Sheet-LA1.1 (page 1 of 6)

1. Provide written documentation from the owner of 5001 E Mercer Way describing the extent and duration of the access.
Written documentation from the owner of 5001 E. Mercer Way has been included with this submittal, see Authorization letters.
2. Where are erosion control measures?
Erosion control measures are demonstrated on the Wall Excavation Plan, Sheet LA2.2
3. The hardscape numbers do not match the Site Development Worksheet. Please double check and update and resubmit the plans and Site Development Worksheet as necessary. Please remember that decks count as hardscape.
The site development worksheet has been updated to the current format released by the City of Mercer Island in January of 2020. Changes are reflected on Sheet LA1.1

2 CAST-IN-PLACE RETAINING WALL - SECTION-2
1/2" = 1'-0" P-RE-MAP1-02

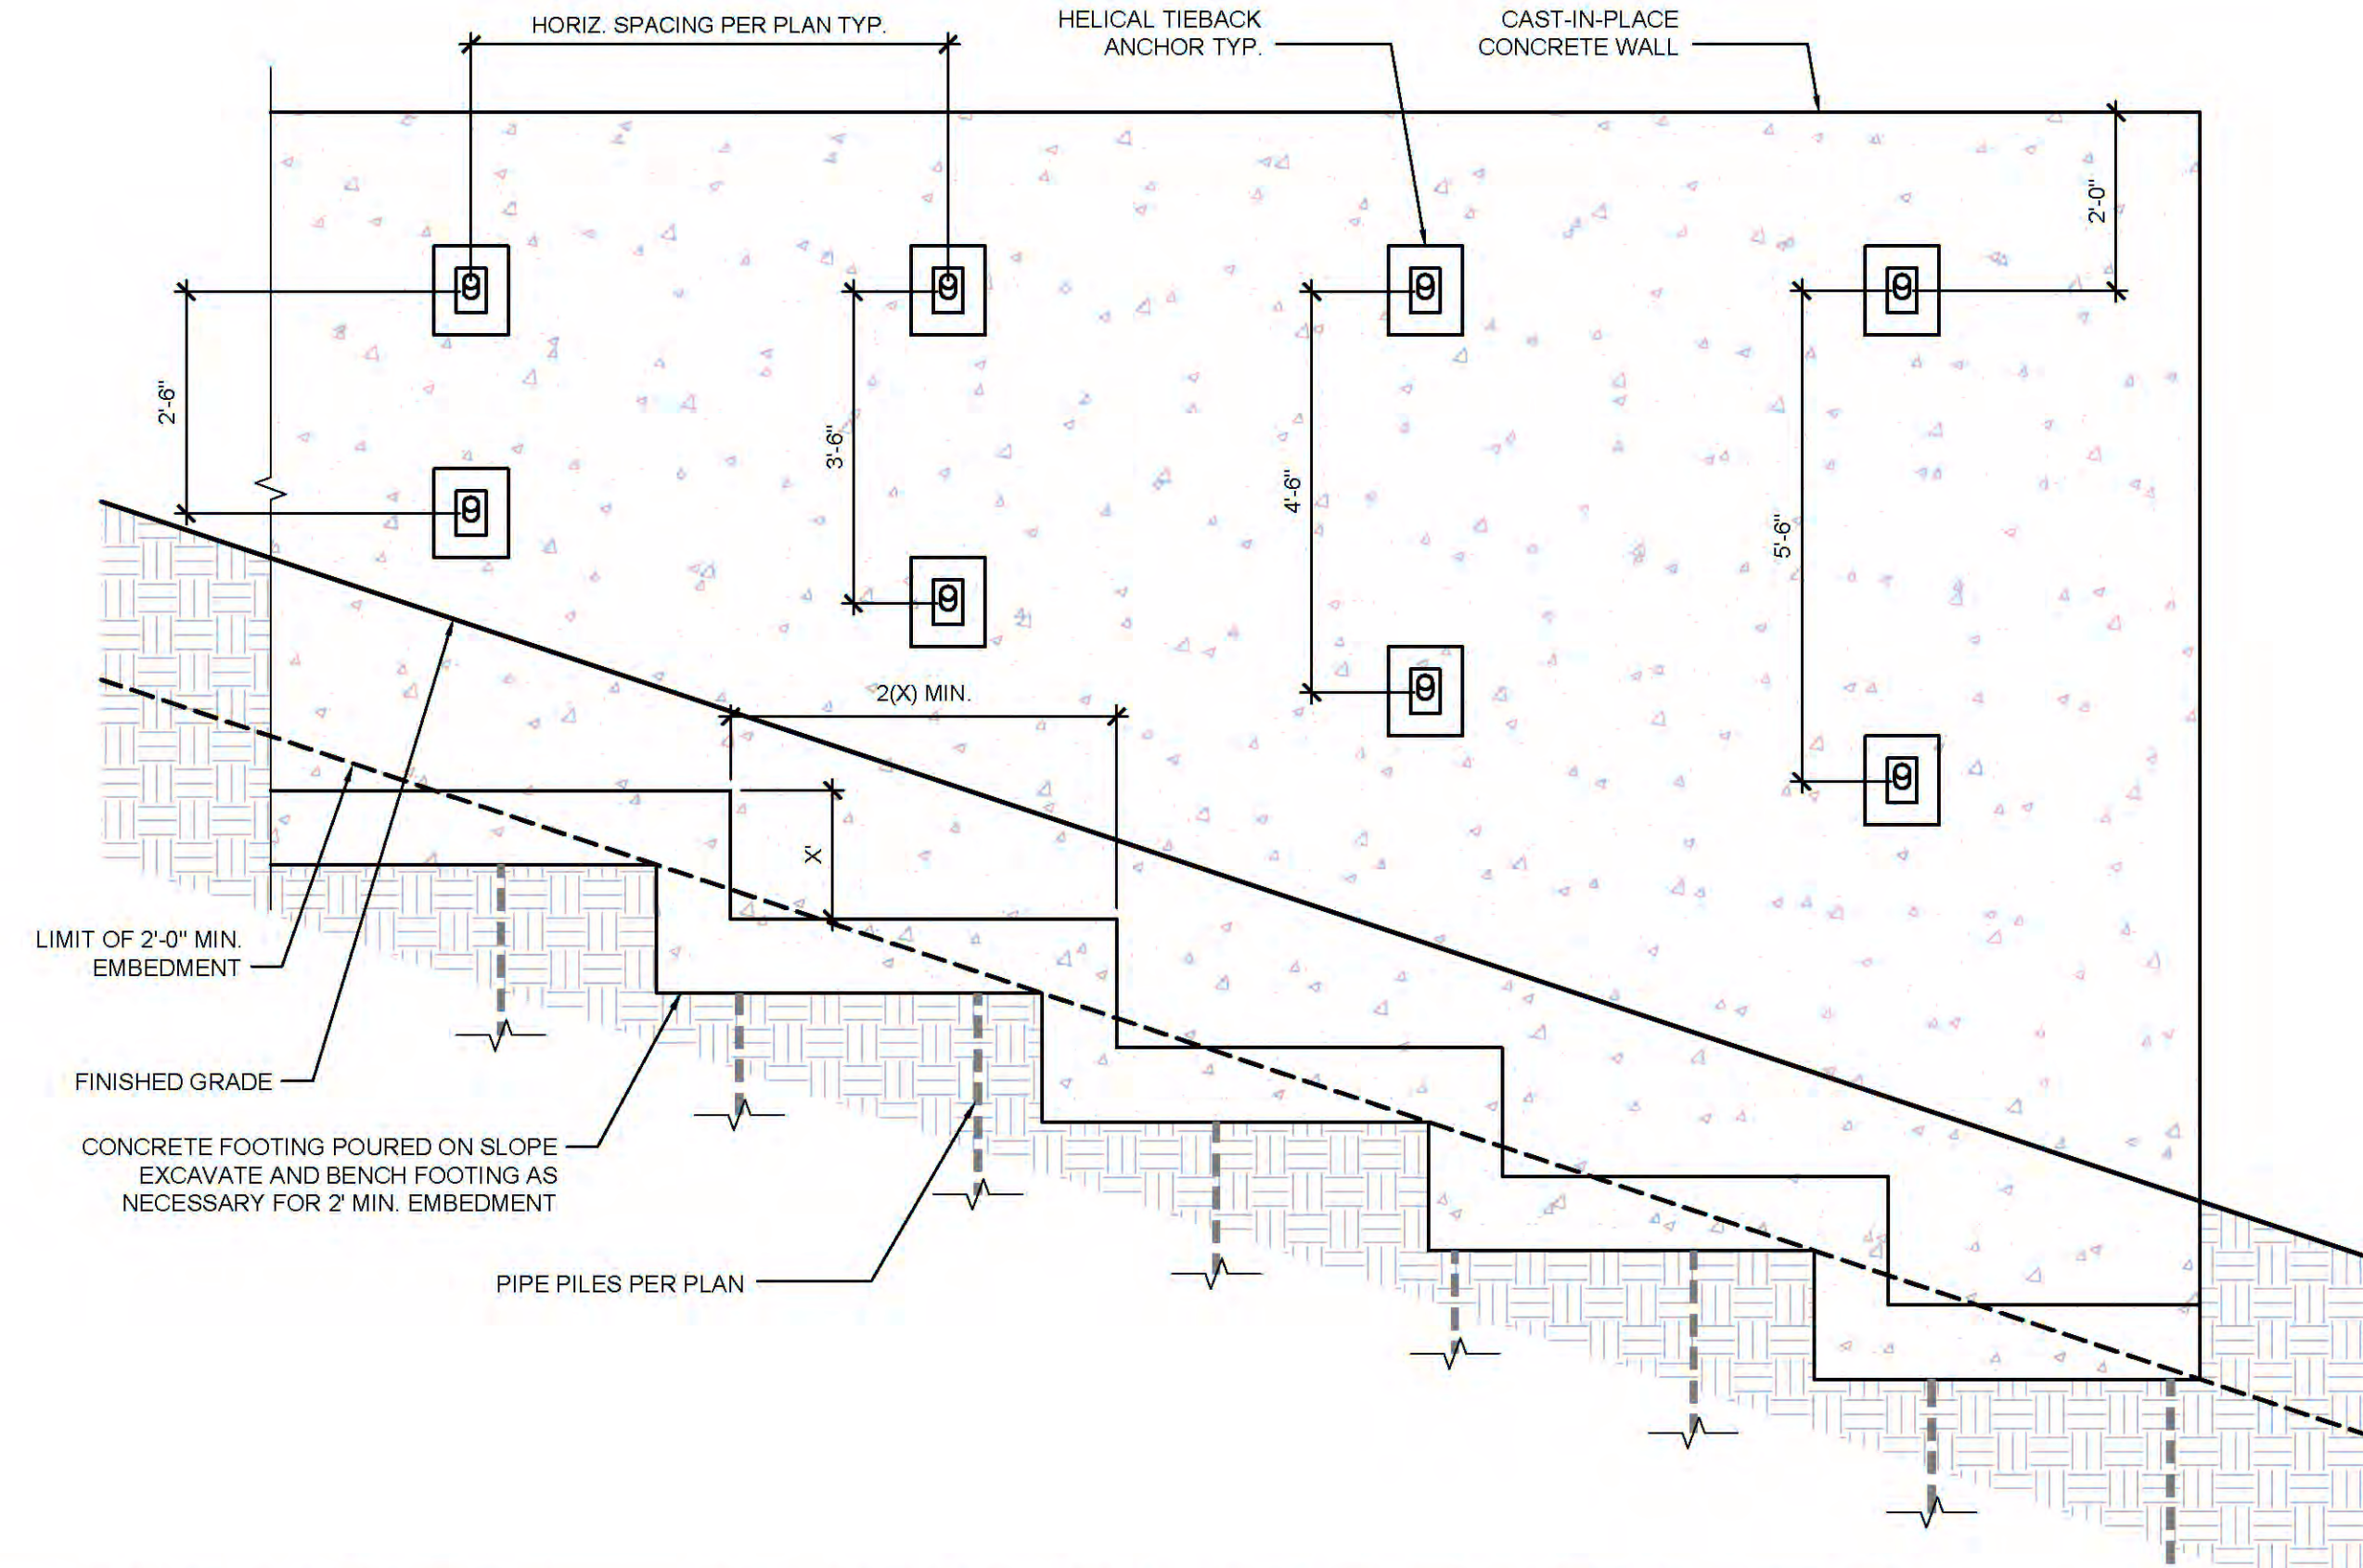
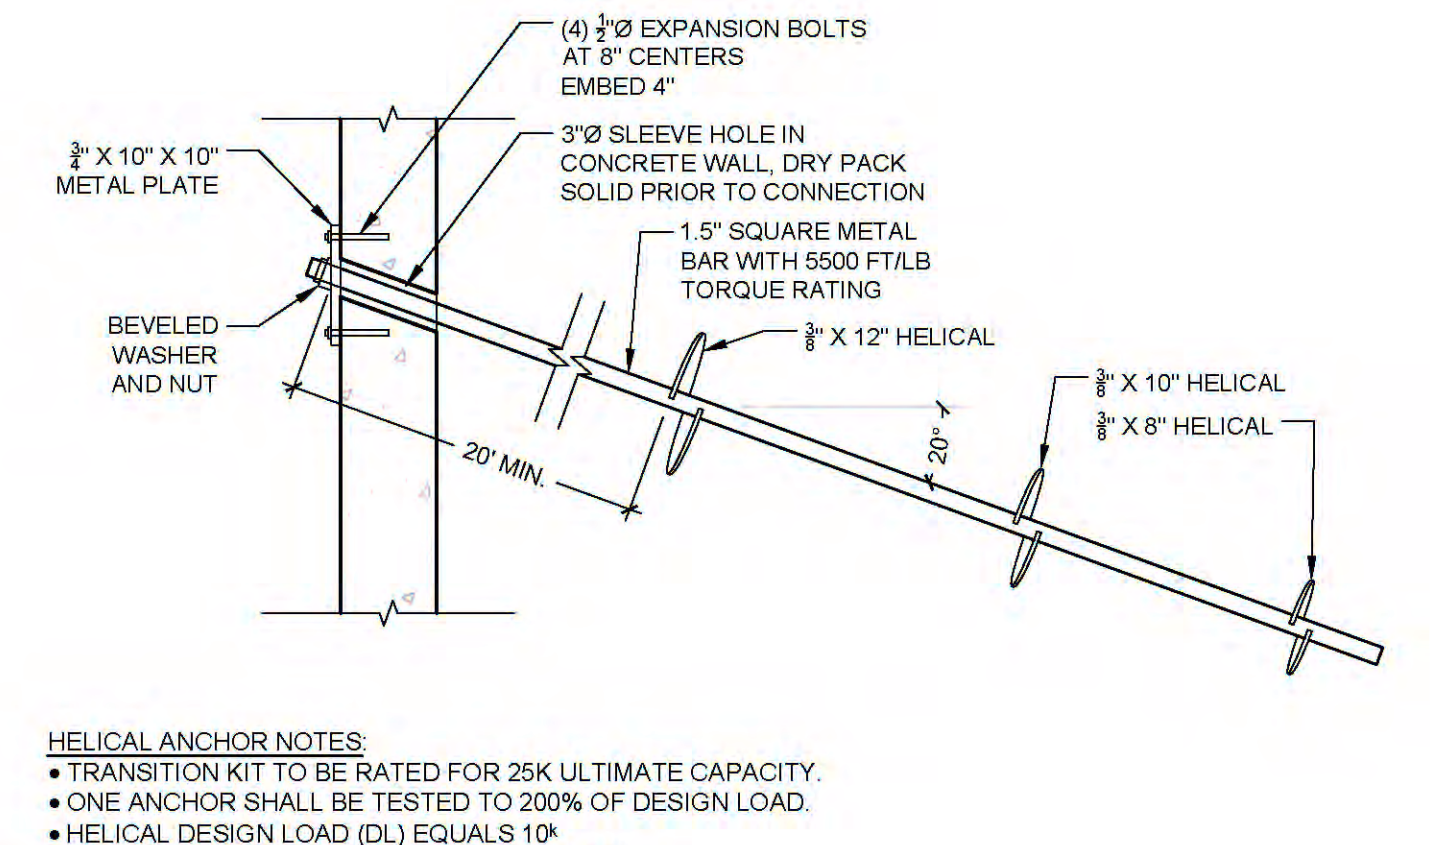
18. The geotechnical report recommends 18-inch width of drainage material along the entire wall height, not 8-inches increasing to 18 inches. Revise all wall sections.
The detail on sheet LA3.2 have been edited to show 18-inch width drainage material along the entire wall height.

19. The proposed drain location does not match the recommendation on plate 3 of the 2019 ESNW Geotech report.
The proposed drain locations have been updated per the 2019 Geotech Report.

20. Wall drainage should not be allowed to exit through wall onto slope in front of wall. Wall drainage should be collected and tight lined to a controlled discharge location (not onto slopes). Revise all wall sections.
Drainage for the wall will be collected by footing drain and tight lined to the nearest storm catch basin.
Please see Wall Drain Plan and Details on Sheets LA2.3 - LA2.5

21. An excavation plan will be required to reflect the temporary excavation necessary for installation. The geotechnical report 2/5/19 recommends a cut of 1.5H:1V on page 2, these details note a maximum of 1:1, and the detail graphically depicts a cut much steeper than this. Please coordinate between all disciplines to correctly reflect the cuts necessary for construction.
Please see the Wall Excavation Plan on sheet LA2.2. Details have been edited to reflect a 1.5H:1V max cut.

23. Provide a detail of the footing reinforcement through a typical step, and a max step height "x"
The allowable vertical step and step reinforcing has been added to detail 4 on sheet LA3.2.

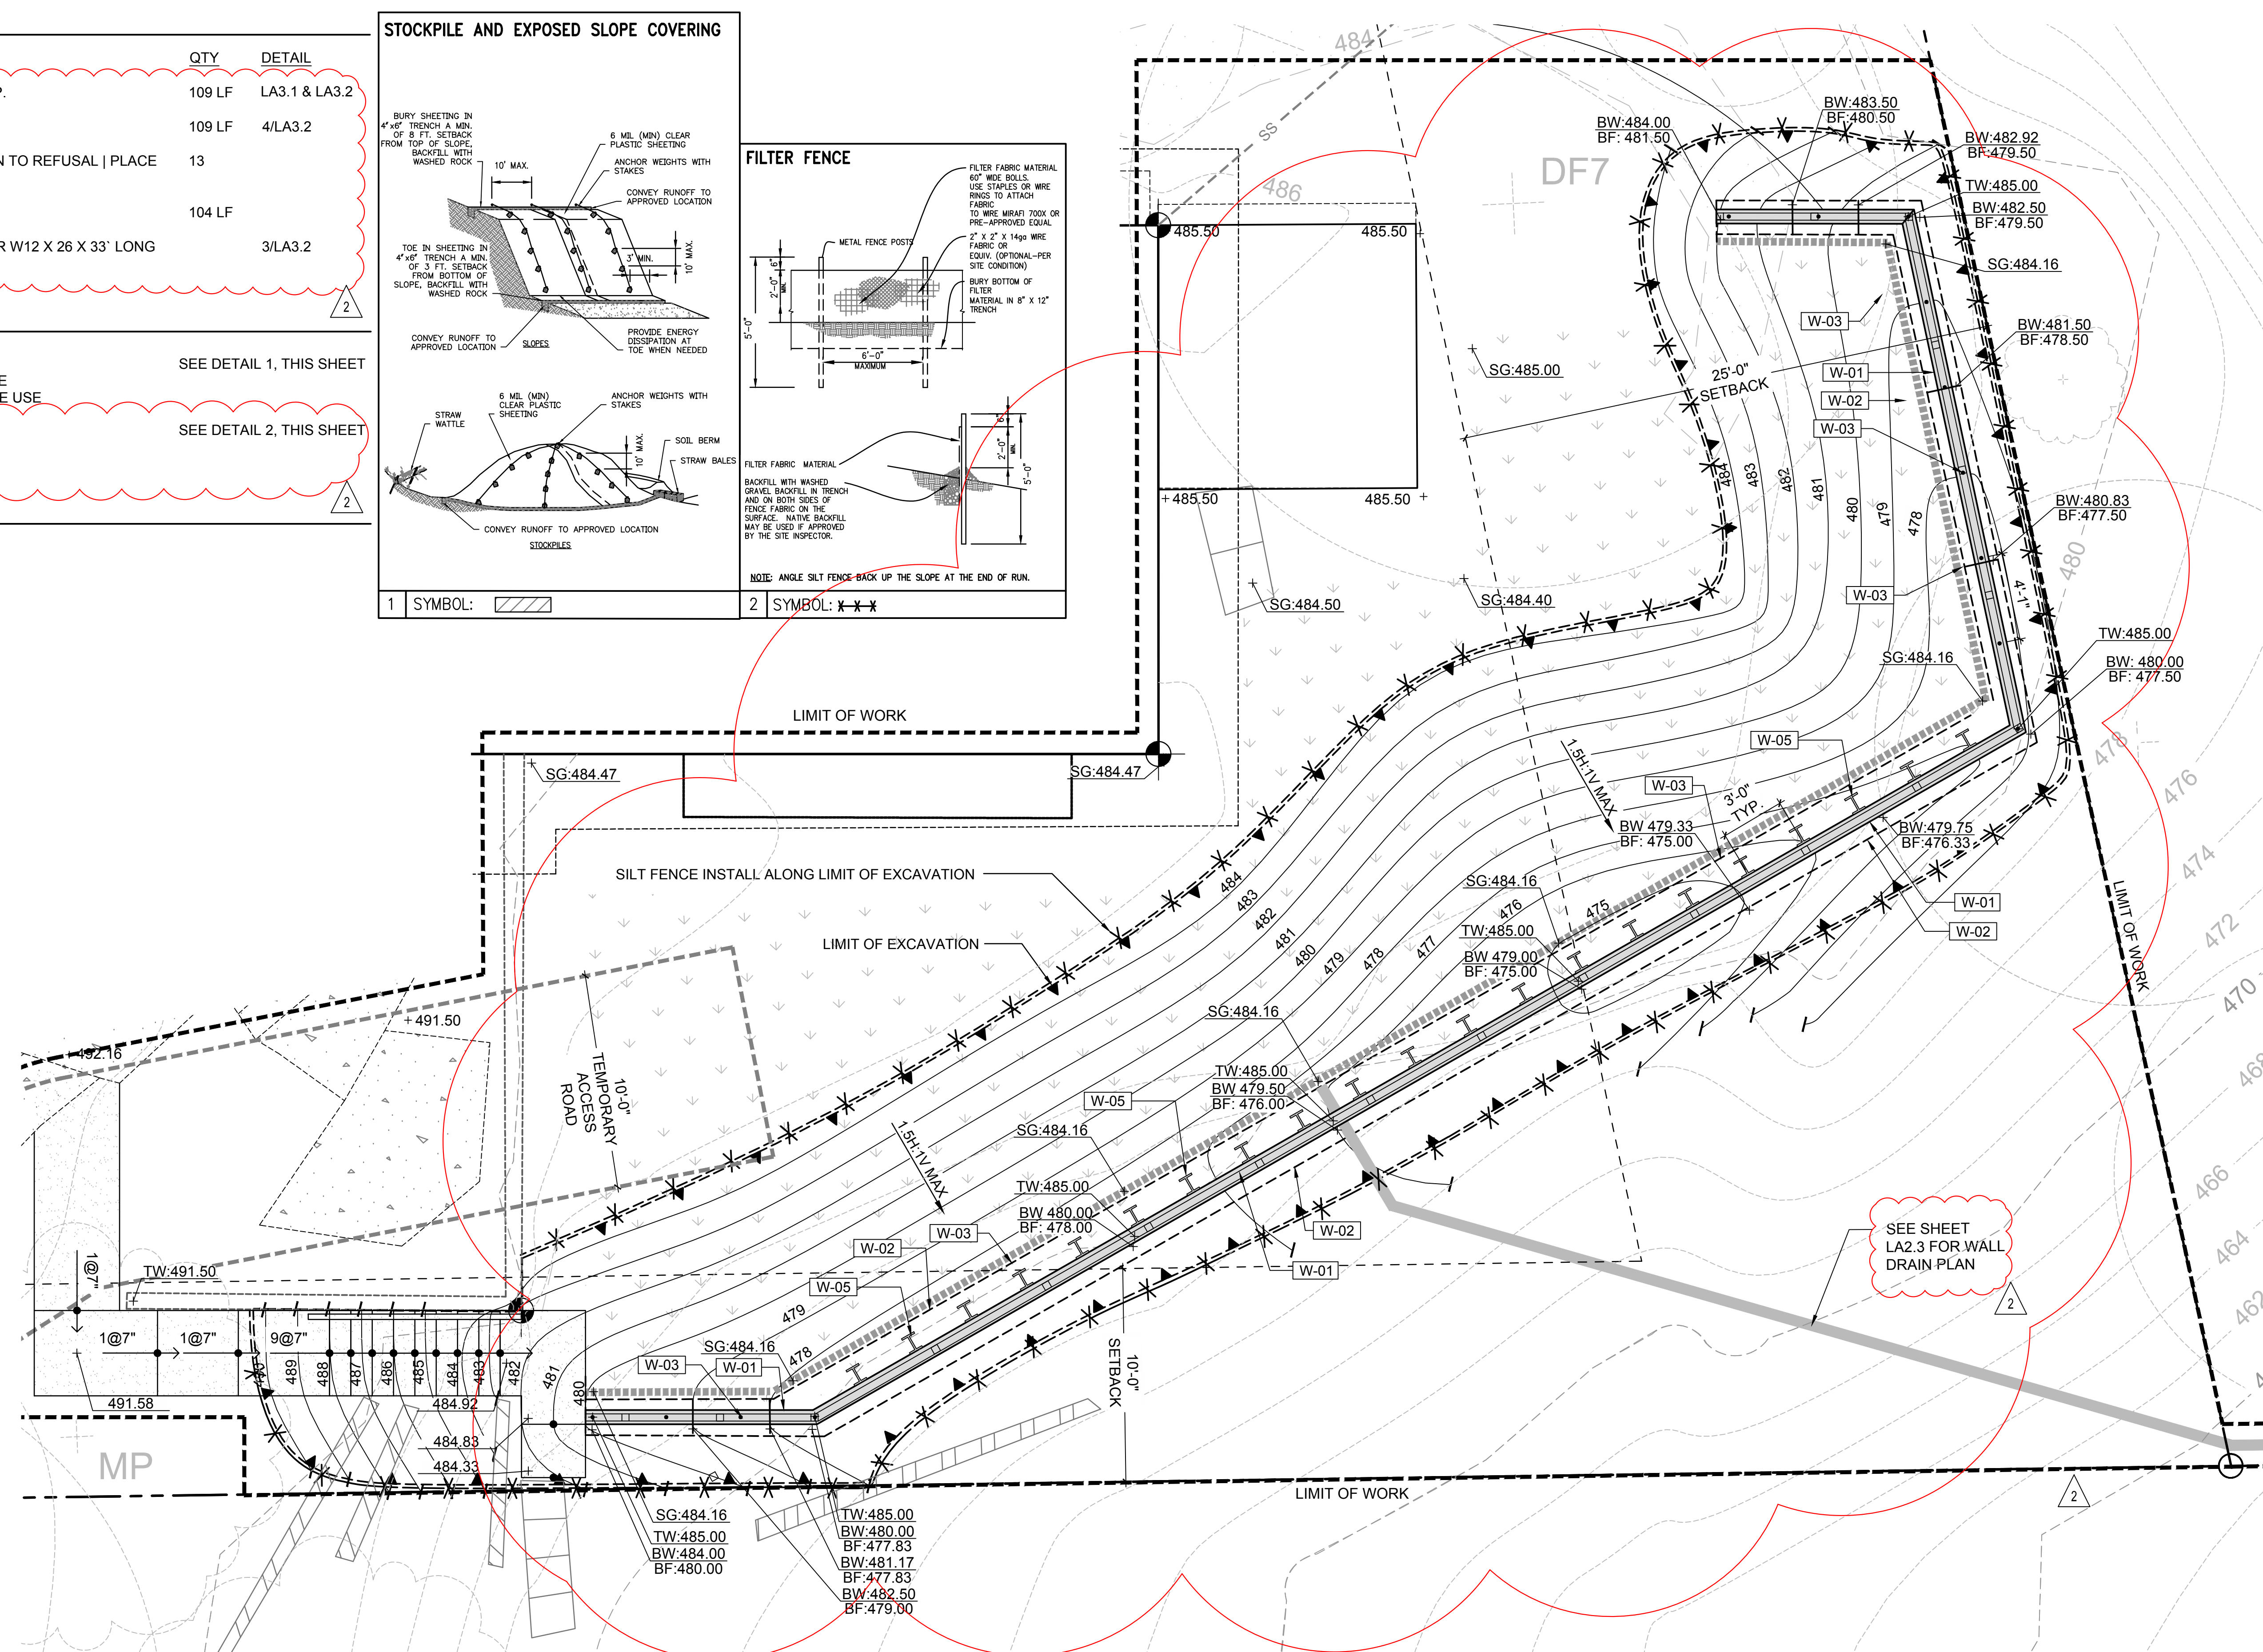
13. ESNW report 2/5/19 and sections on LA3.1 indicate the proposed wall will be constructed using temporary benches and toe slope open cuts. Provide an excavation plan reflecting the anticipated bottom of excavation and all temporary slopes to accommodate the installation of all wall, foundation, and drainage system including footing step locations.

Please see the Wall Excavation Plan on sheet LA2.2.
